KITTITAS COUNTY COMMUNITY DEVELOPMENT SERVICES

August 14, 2014

Subject: Suckert Boundary Line Adjustment (BL-14-00014)

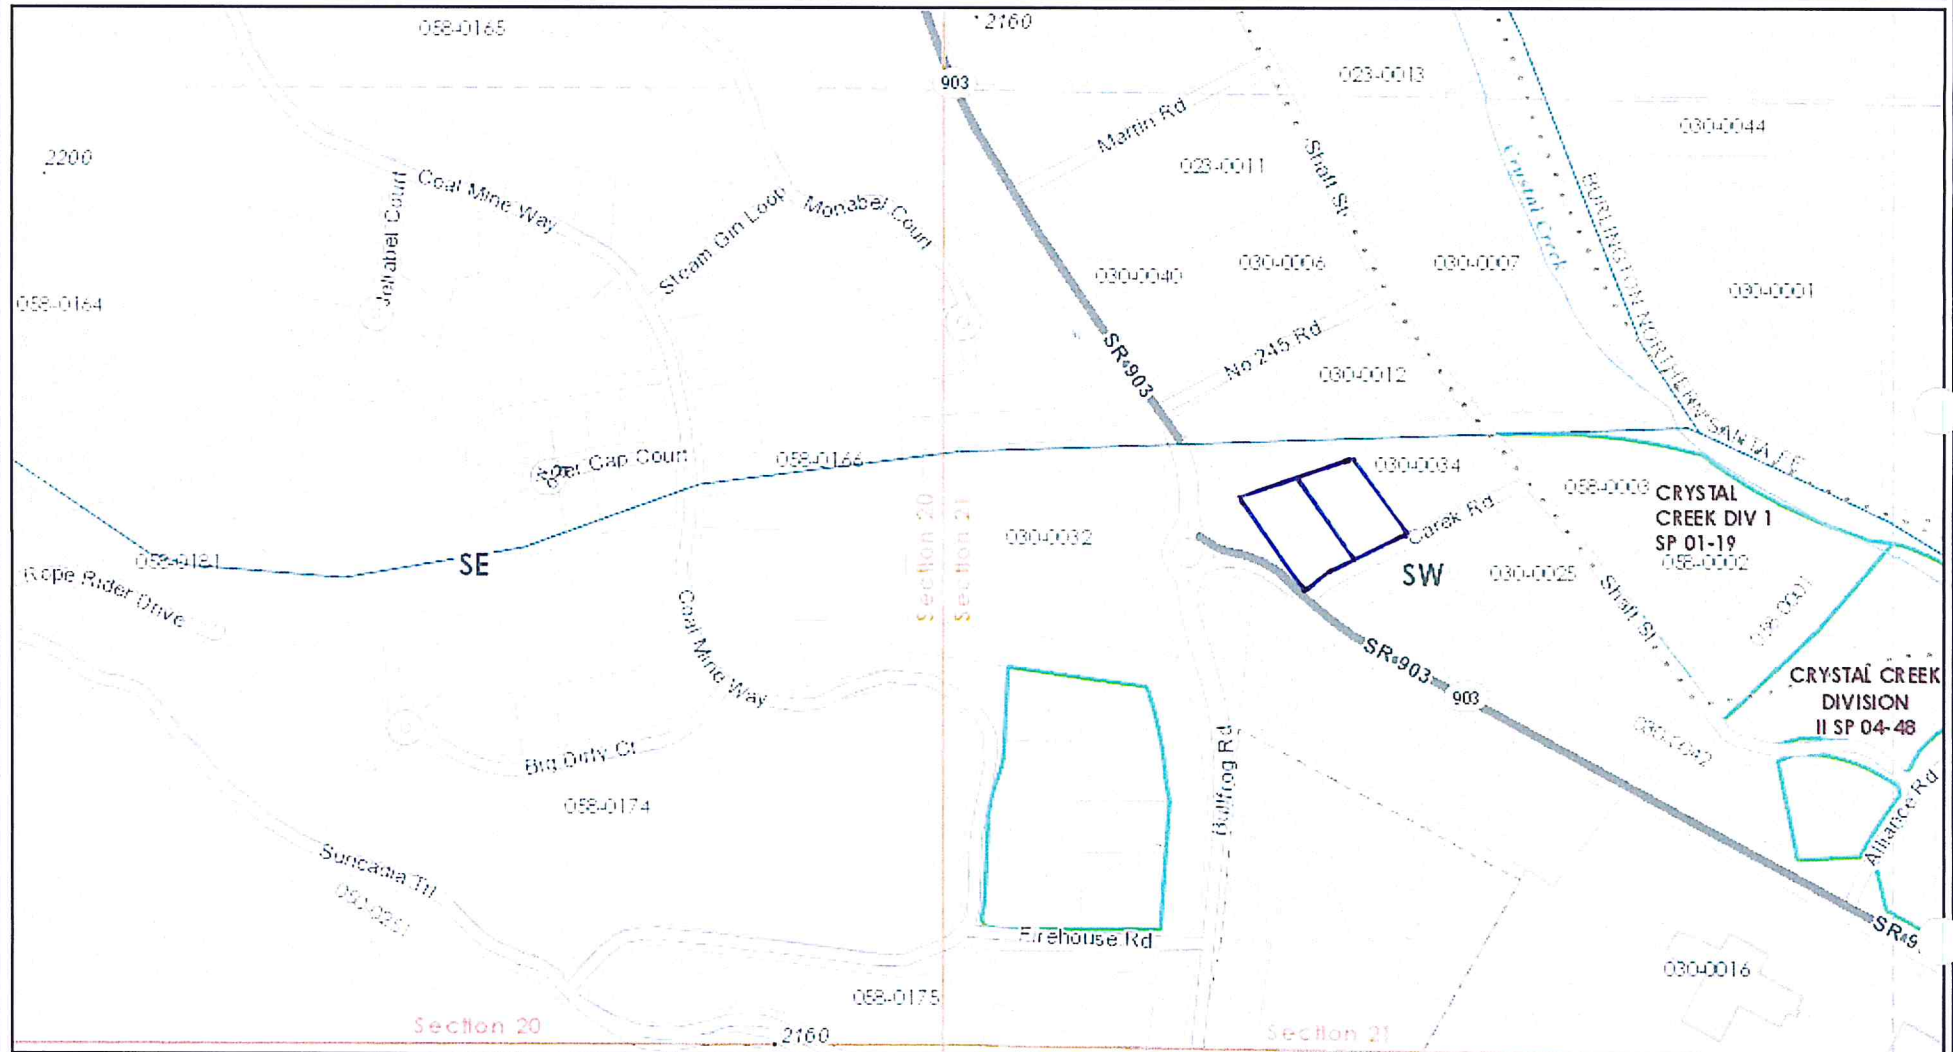
- ***Location of Septic fields on all parcels associated with Boundary Line Adjustment on a proposed and existing site plan.***
